**From:** Sarah Burrow <Sarah.Burrow@arun.gov.uk>  
**Sent:** 22 November 2022 13:36  
**To:** Planning.Responses <Planning.Responses@arun.gov.uk>  
**Cc:** Maria Tomalova <Maria.Tomalova@arun.gov.uk>  
**Subject:** RE: Planning Consultation on: BN/26/22/PL

Engineers Comments Regarding Surface Water Drainage

**Application No:** BN/26/22/PL  
**Registered:** 28th March 2022  
**Site Address:** Land East of Eastmere House Eastergate Lane Eastergate PO20 3SJ  
**Grid Reference:** 495273 106065  
**Category:** Plan Applicat'n

**Description of Works:** Construction of 1 No. two storey detached dwelling house on existing paddock. This application is a Departure from the Development Plan and is in CIL Zone 3 and is CIL Liable as new dwelling.

CLIENT		MR & MRS STRUDWICK			
ARCHITECT		FOLKES ARCHITECTS			
JOB TITLE		LAND AT EASTERGATE LANE EASTERGATE			
DRAWING TITLE		SURFACE WATER DRAINAGE LAYOUT			
DRAWN	LH	ENGINEER	C SLADE	CHECKED	CS
DATE	MARCH 2022	SCALE @ A1	1:100	APPROVED	CS
JOB No.	C2027	STATUS	PL	DRAWING No.	100
REV					PL1

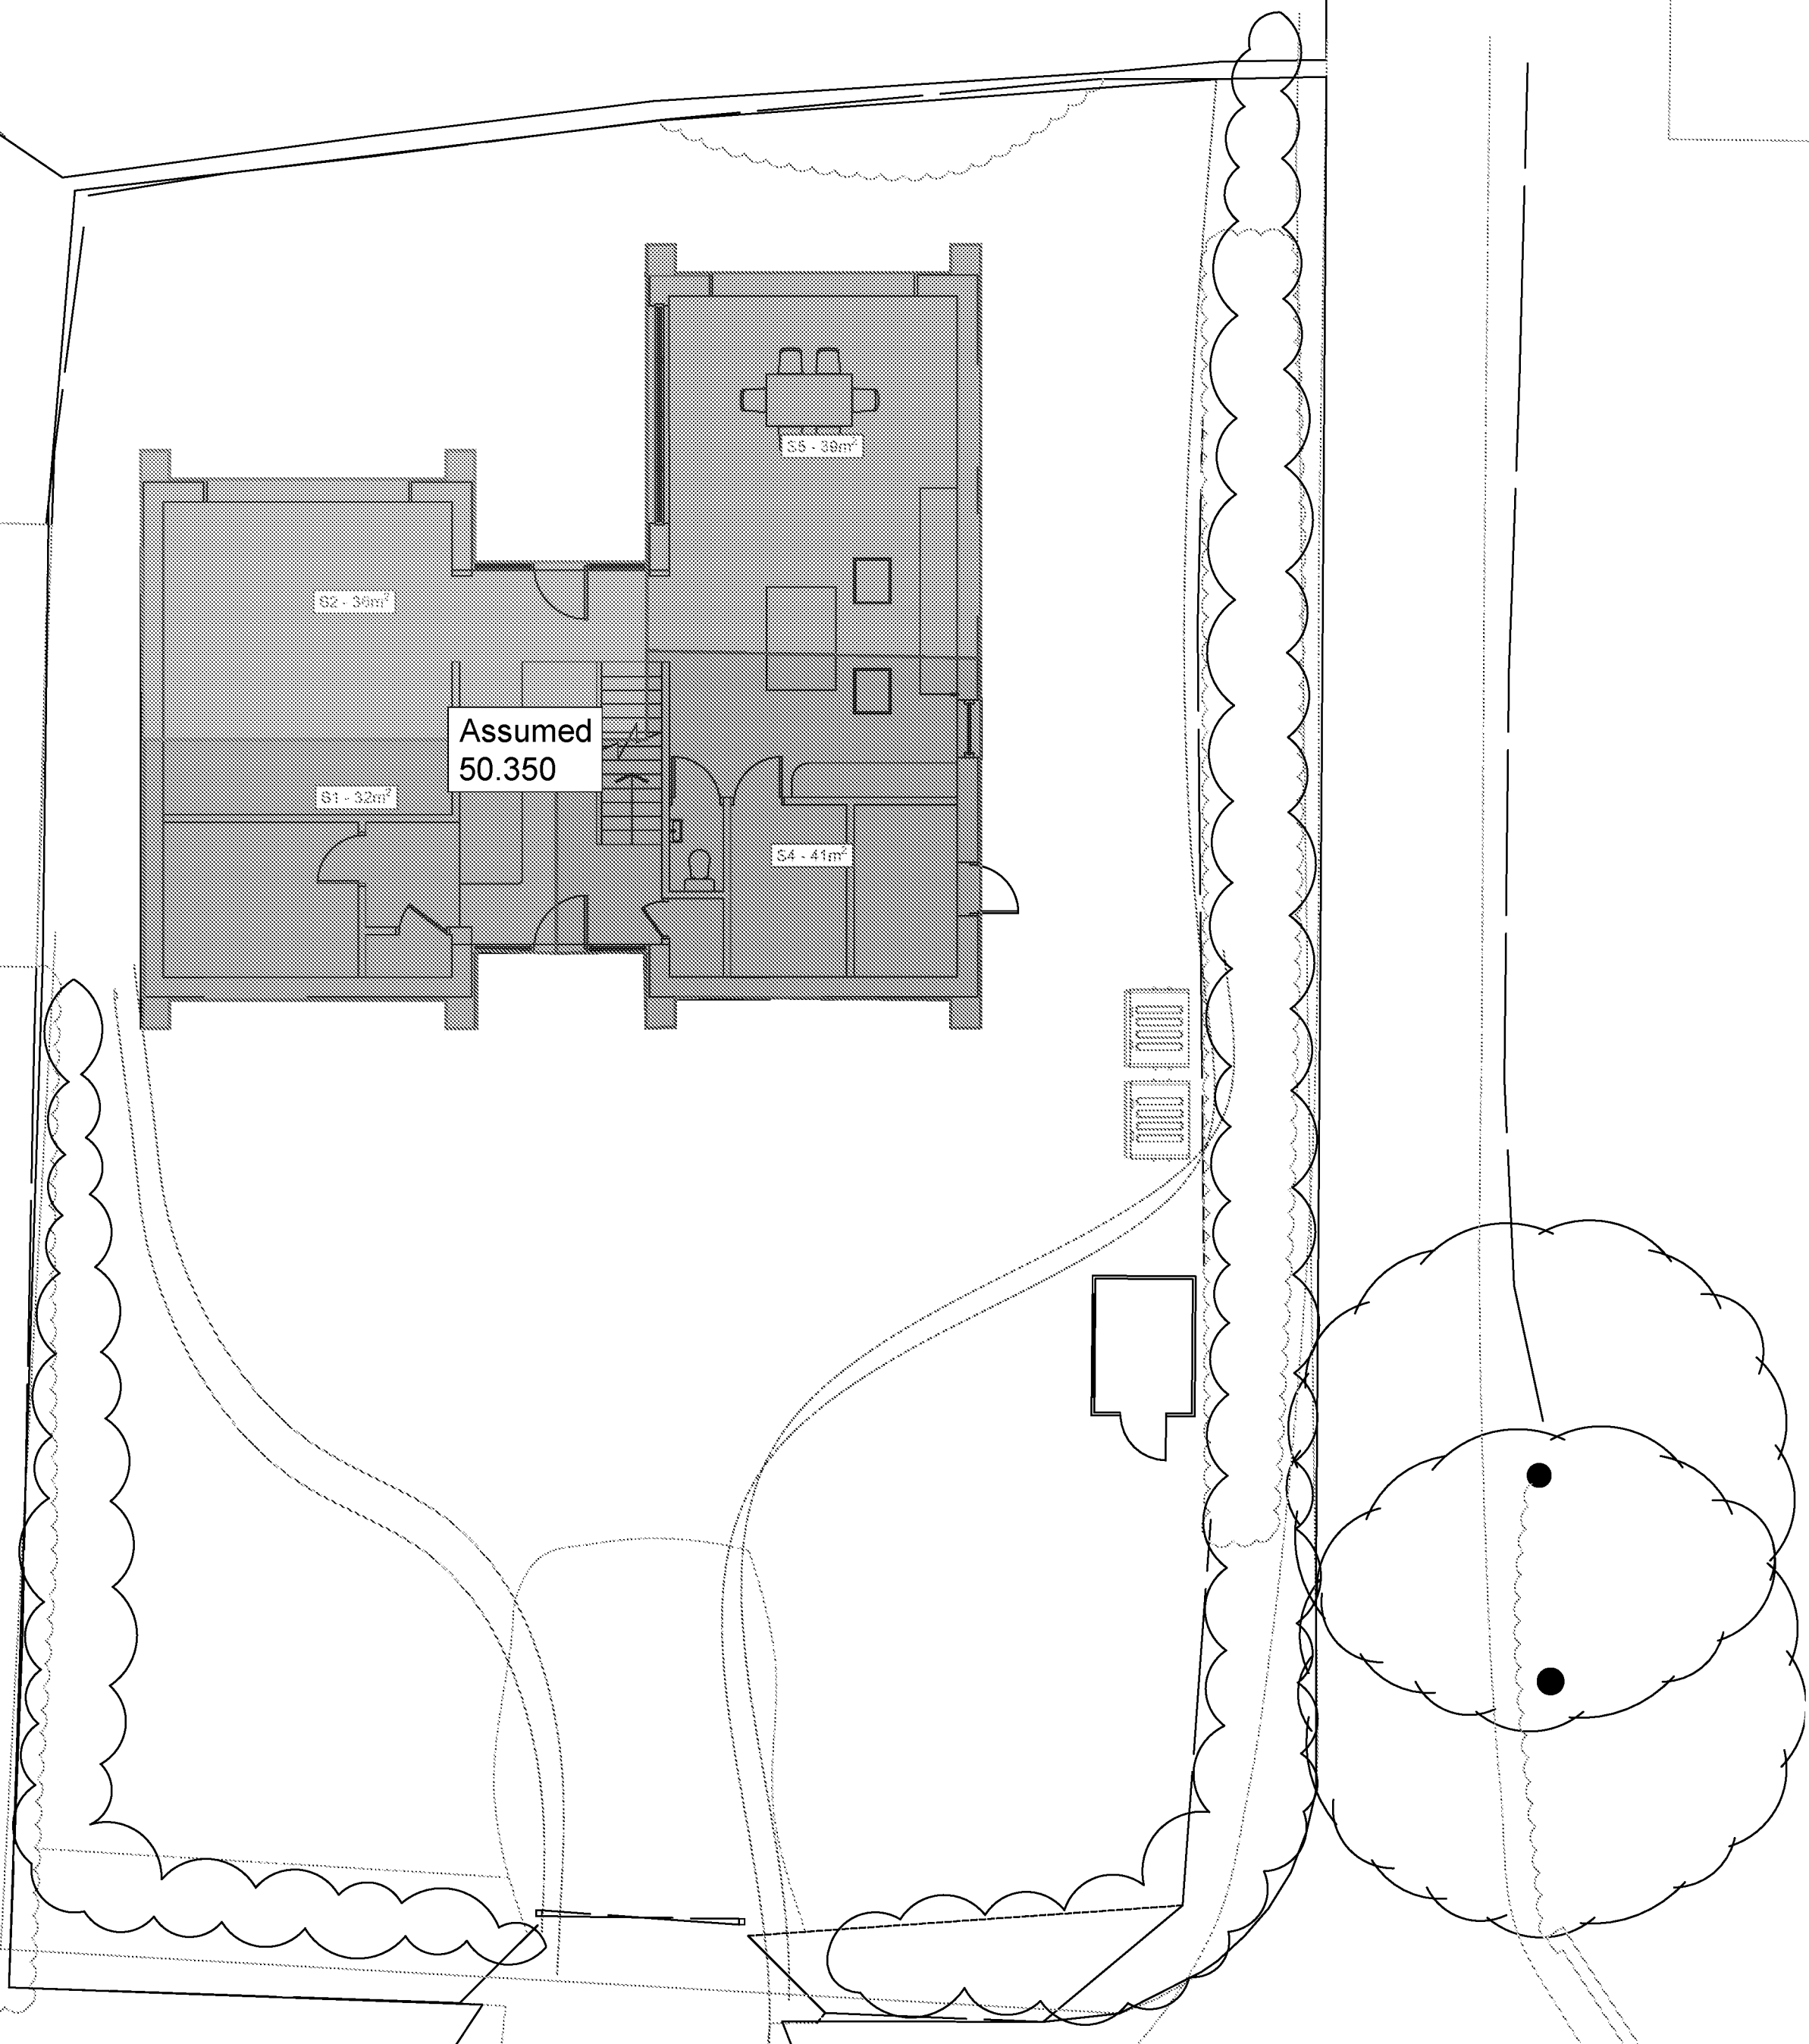
3. **The proposed soakaway appears to be located outside the red line boundary for the site. Either the design or the red line boundary should be adjusted so that the full surface water drainage design is within the red line boundary.**
